PLANNING AMENDMENT

Application No. H13/0715/02/H1

PROPOSAL FOR A GARAGE

Amendment: Revised bricks (Baggeridge Harvest Buff) & tiles (Sandtoft Double Pantile "Bracken").

Drawing
FLOOR PLAN / SECTION / ELEVATIONS

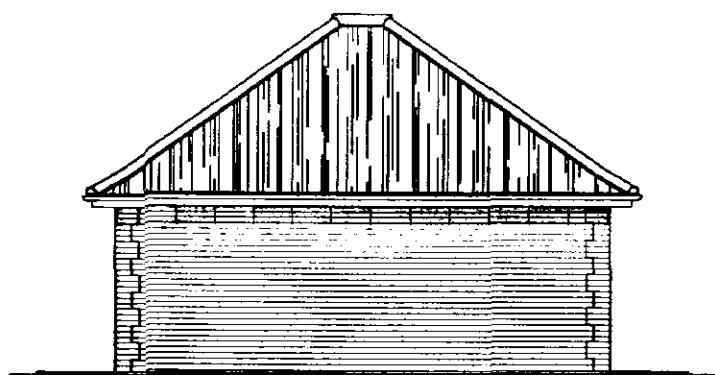
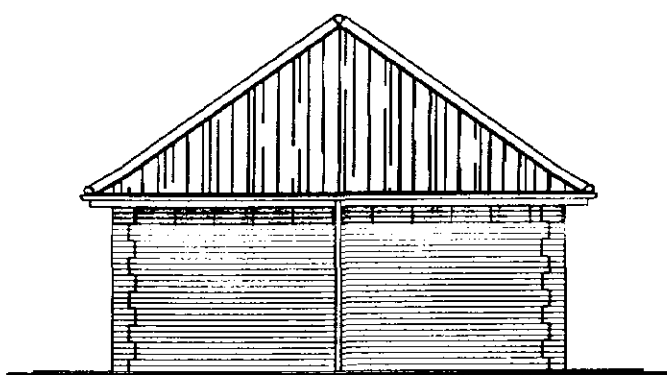
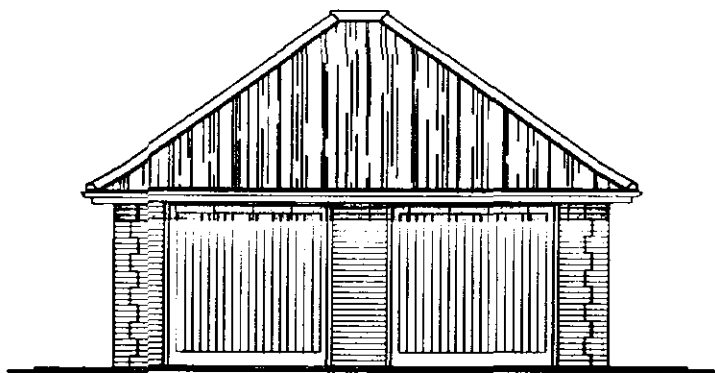
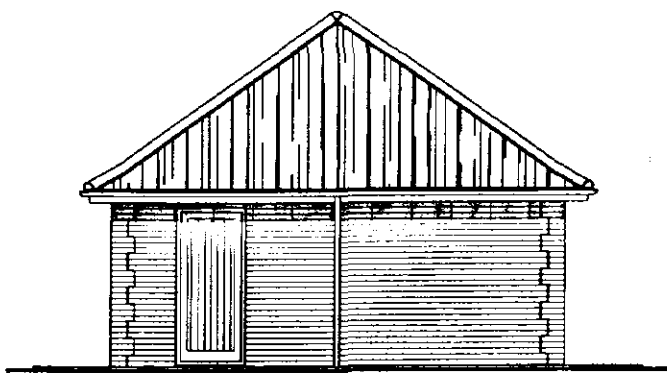
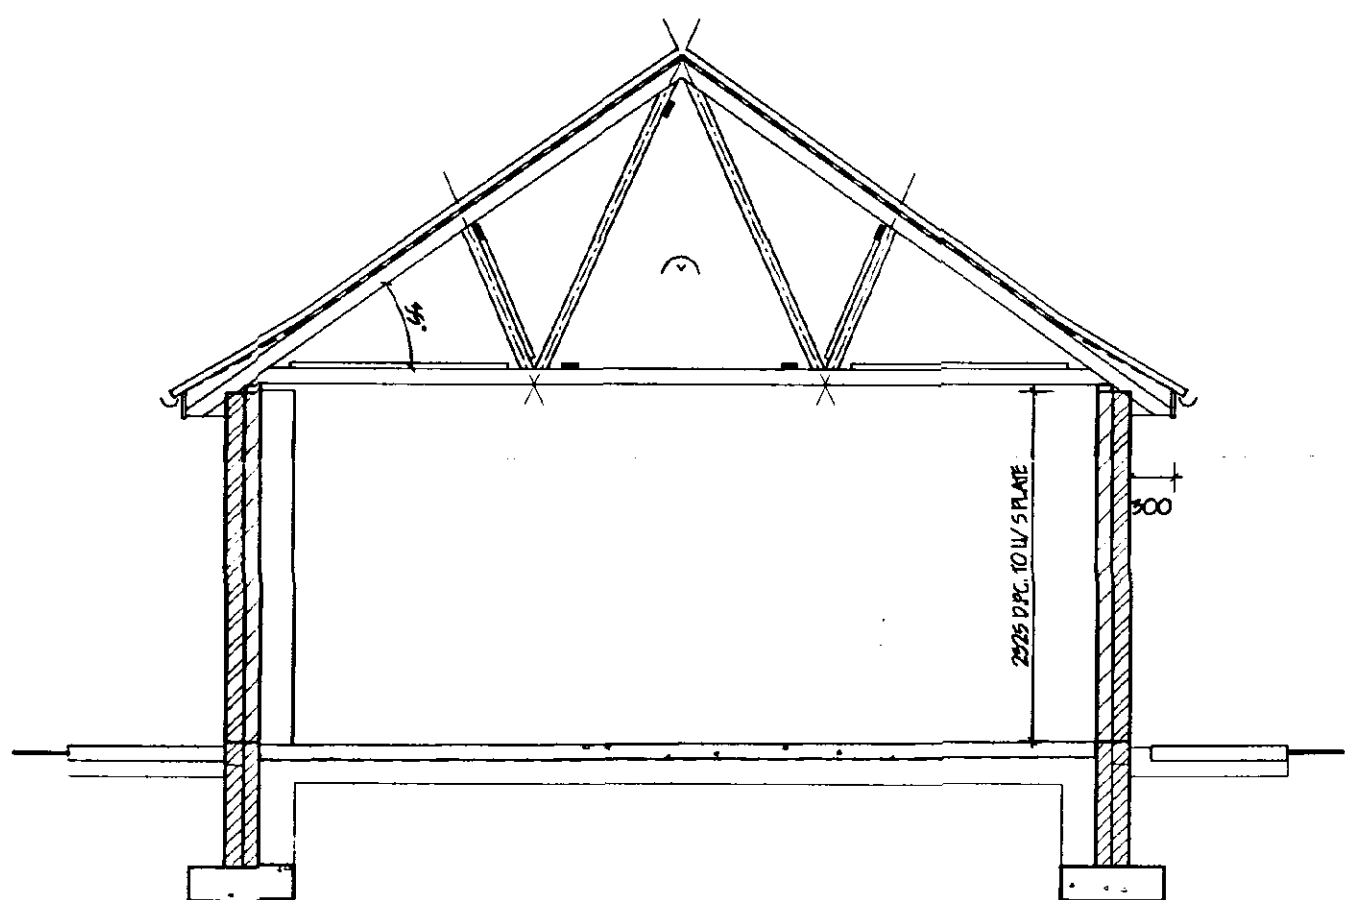
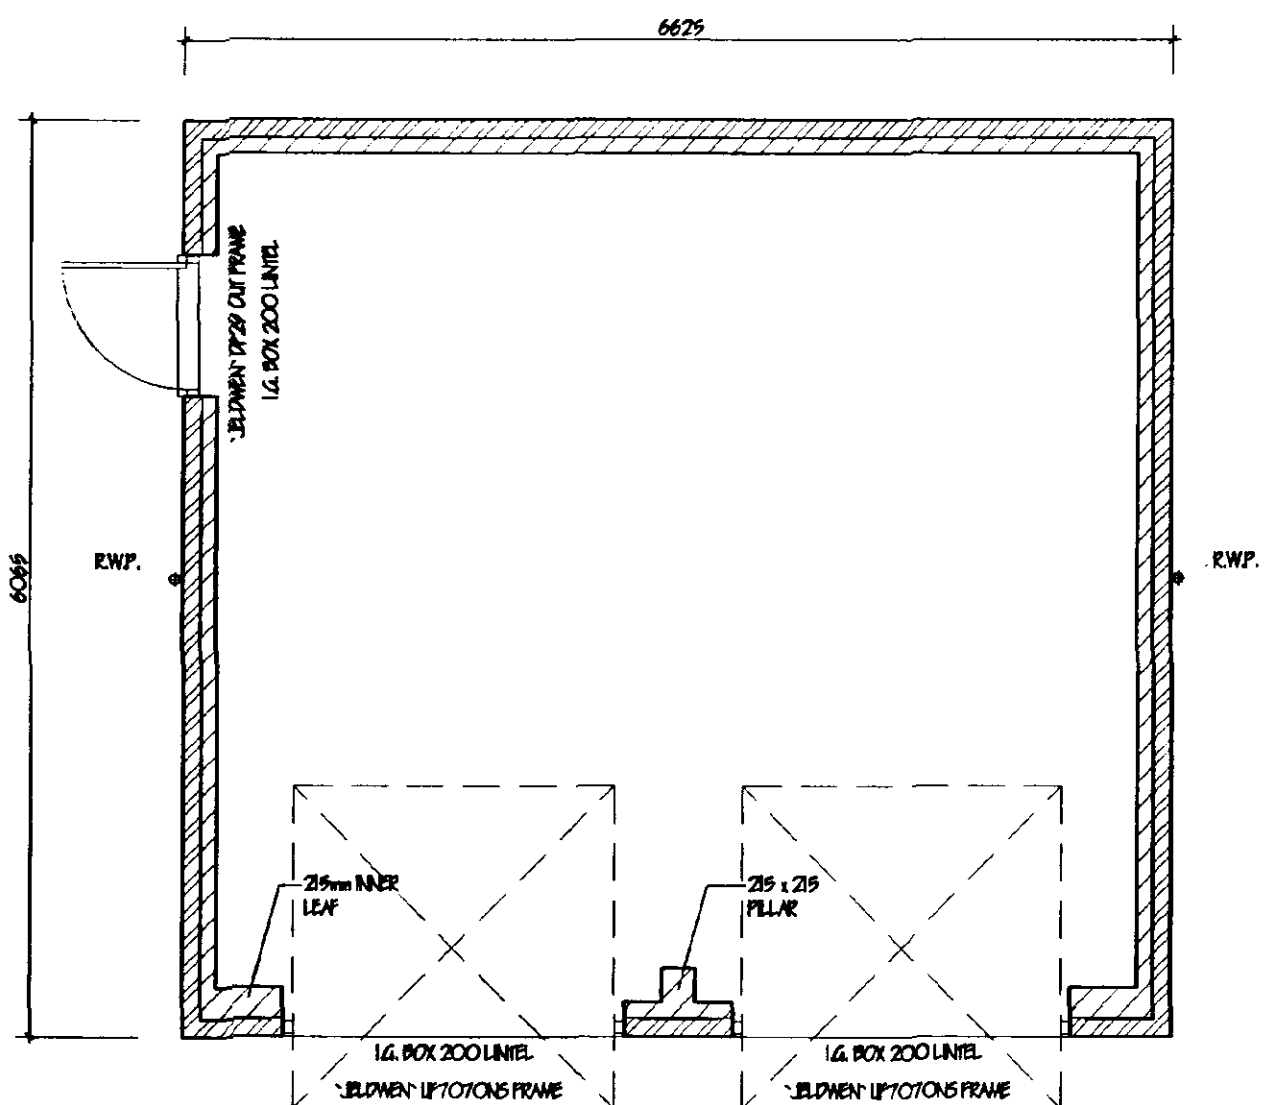
REPLACE THE EXISTING GARAGE WITH A NEW ONE
THE NEW GARAGE WILL BE 10'0" DEEP AND 10'0" WIDE
THE EXISTING GARAGE WAS 8'0" DEEP AND 8'0" WIDE
